Our Ref: 2021/94296
Date: 05-Jan-2022

**TOWN AND COUNTRY PLANNING ACT 1990
TOWN AND COUNTRY PLANNING (GENERAL PERMITTED DEVELOPMENT)
(ENGLAND) ORDER 2015 - APPLICATION NO:2021/N /94296/E
DEVELOPMENT: PRIOR NOTIFICATION FOR THE INSTALLATION OF A 16.0M
PHASE 8 MONOPOLE C/W WRAPROUND CABINET AT BASE AND ASSOCIATED
ANCILLARY WORKS (WITHIN A CONSERVATION AREA) LANE HEAD ROAD,
SHEPLEY, HUDDERSFIELD, HD8 8DB**

The proposal is not acceptable to the Council, and notice is hereby given that the details submitted have been refused.

Title:
260 PROPOSED ELEVATION

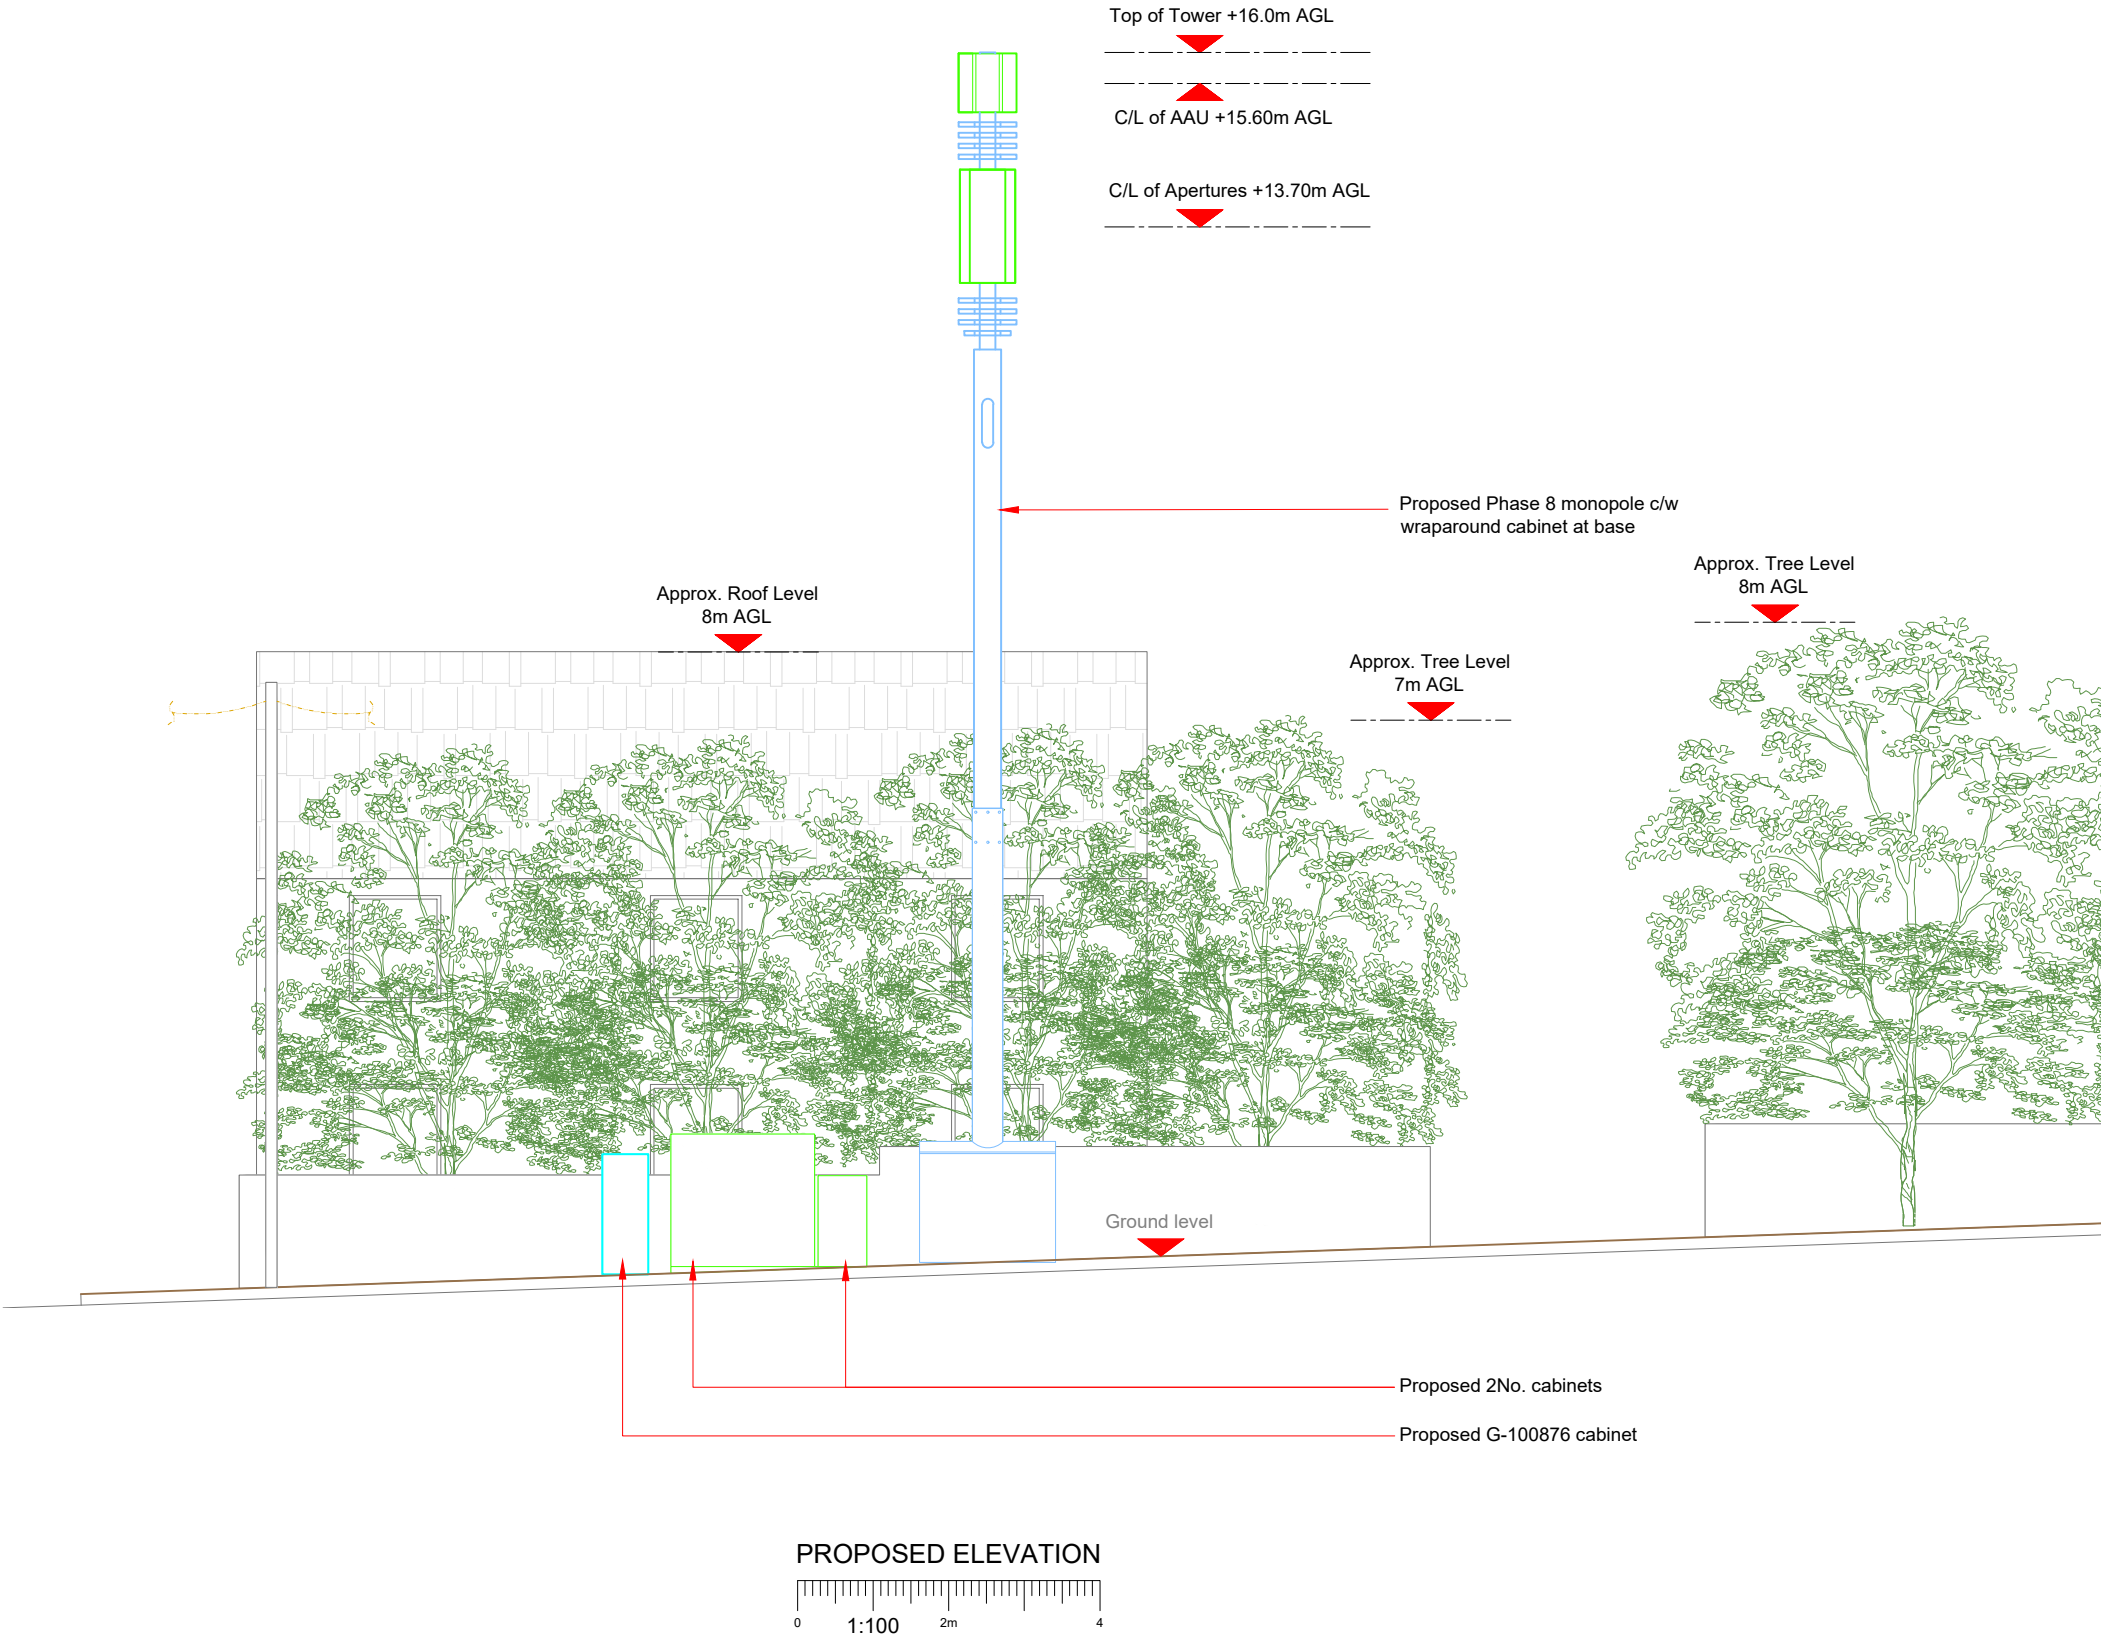
1. The proposed mast, by reason of its siting, size and appearance in regard to form and colour would be a visually intrusive and incongruous feature in the streetscape appearing wholly out of scale with the surrounding residential properties and failing to respect the character of the area. The siting, size and appearance would also fail to conserve or respect the character of the Shepley Conservation Area setting as required by Local Plan policy. The proposed development would therefore be contrary to Policies LP24 and LP35 of the Kirklees Local Plan and Chapters 12 and 16 of the National Planning policy Framework.

2. The proposed mast, by reason of its siting, size and appearance would not ensure a good standard of amenity for neighbouring occupiers. The siting of a 16m mast in such a close proximity to the principal elevation of dwellings would appear overbearing and cause undue harm. To permit the development would be contrary to Kirklees Local Plan Policy LP24 with regard to the impact on the residential amenity of neighbouring occupiers.
